Addendum No. 1

RE: Contract ID C203206

Cabarrus-Mecklenburg Counties (P-5208A, C & G)

North Carolina Railroad/ Norfolk Southern Mainline Haydock to Junker
Railroad Roadbed (MP-360 To MP-372.2)

STATE	STATE PROJECT REFERENCE NO.	SHEET NO.	TOTAL SHEETS
N.C.	P-5208C	EC-01	
STATE PROJ. NO.	F.A. PROJ. NO.	DESCRIPTION

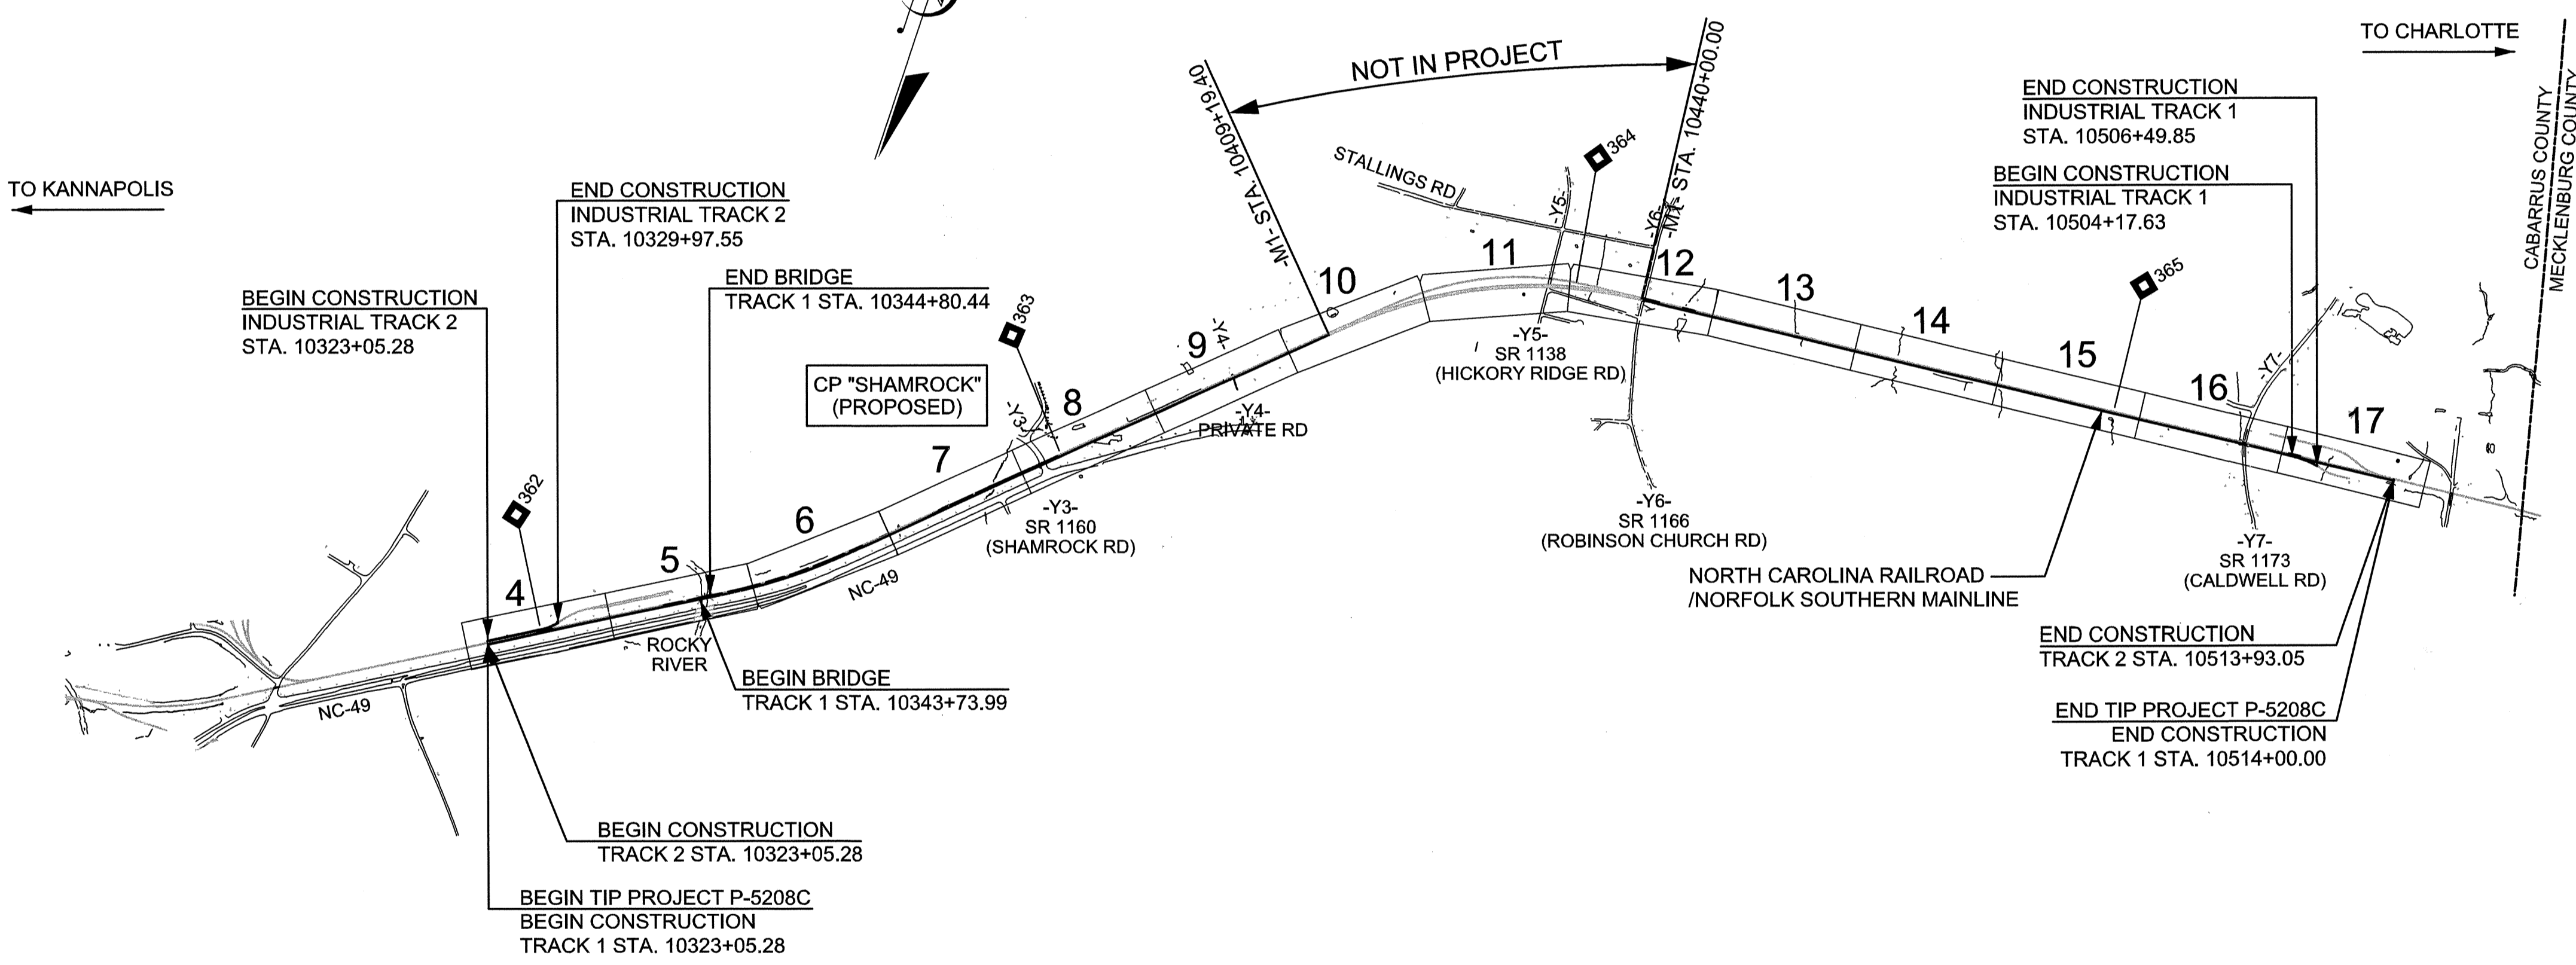
Sheet No.	Revisions
1	Revised stationing for -Y6-. (Please note that this sheet should be the main title sheet for P-5208A but was incorrectly printed in the original printing as EC-01)
2	Right side of typical #2 revised to change the width and depth of sub-ballast
2A	Revised typical sections for -Y6-
2F	Added sub-surface drain
3A	Revised drainage structure number C0802
3C	Revised quantity for select granular material
8	Subsurface drain added plan view. Saddle Creek Rd. (-Y6-) design updated
25	Revised profile for Saddle Creek Rd. (-Y6-)
EC-01	Added note concerning 303d waters
EC-08	Saddle Creek Rd. (-Y6-) design updated

PROJECT REFERENCE NO. P-5208C
SHEET NO. EC-22/CONST. 8

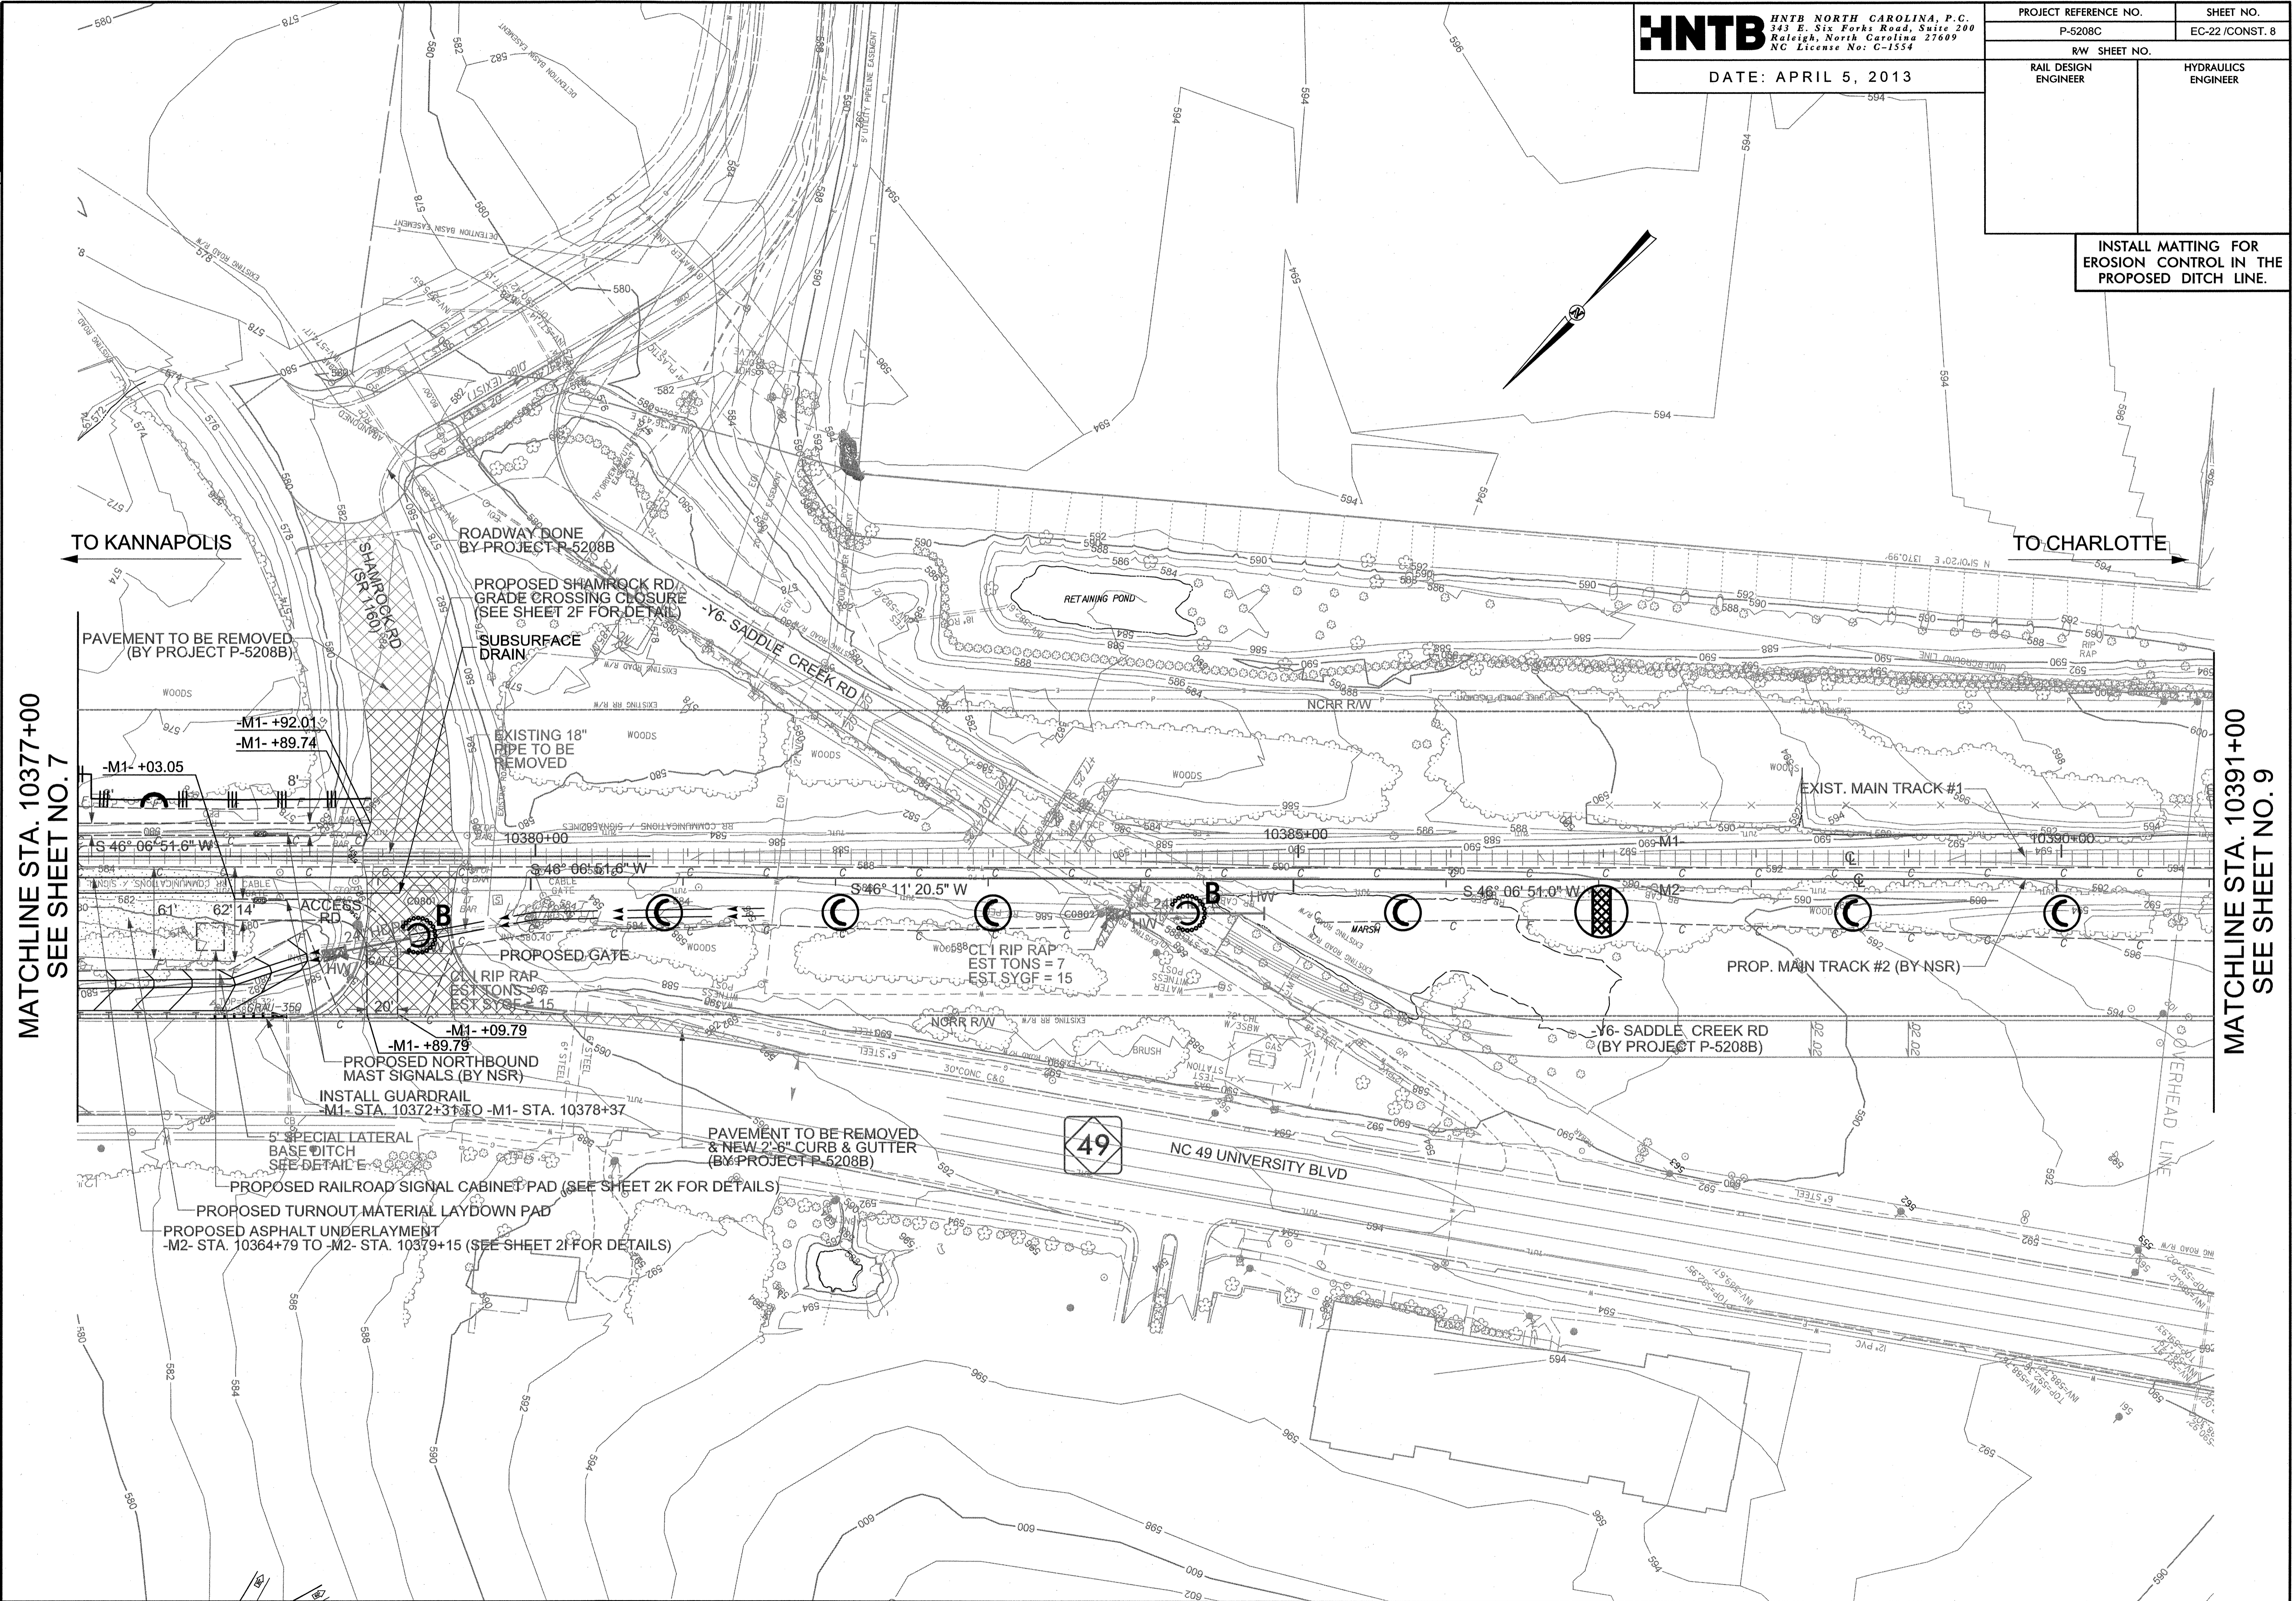
Sheet No.	Revisions
EC-22	Saddle Creek Rd. (-Y6-) design updated
X-23 thru X-27, X-47 and X-57,	Added subsurface drains to cross sections
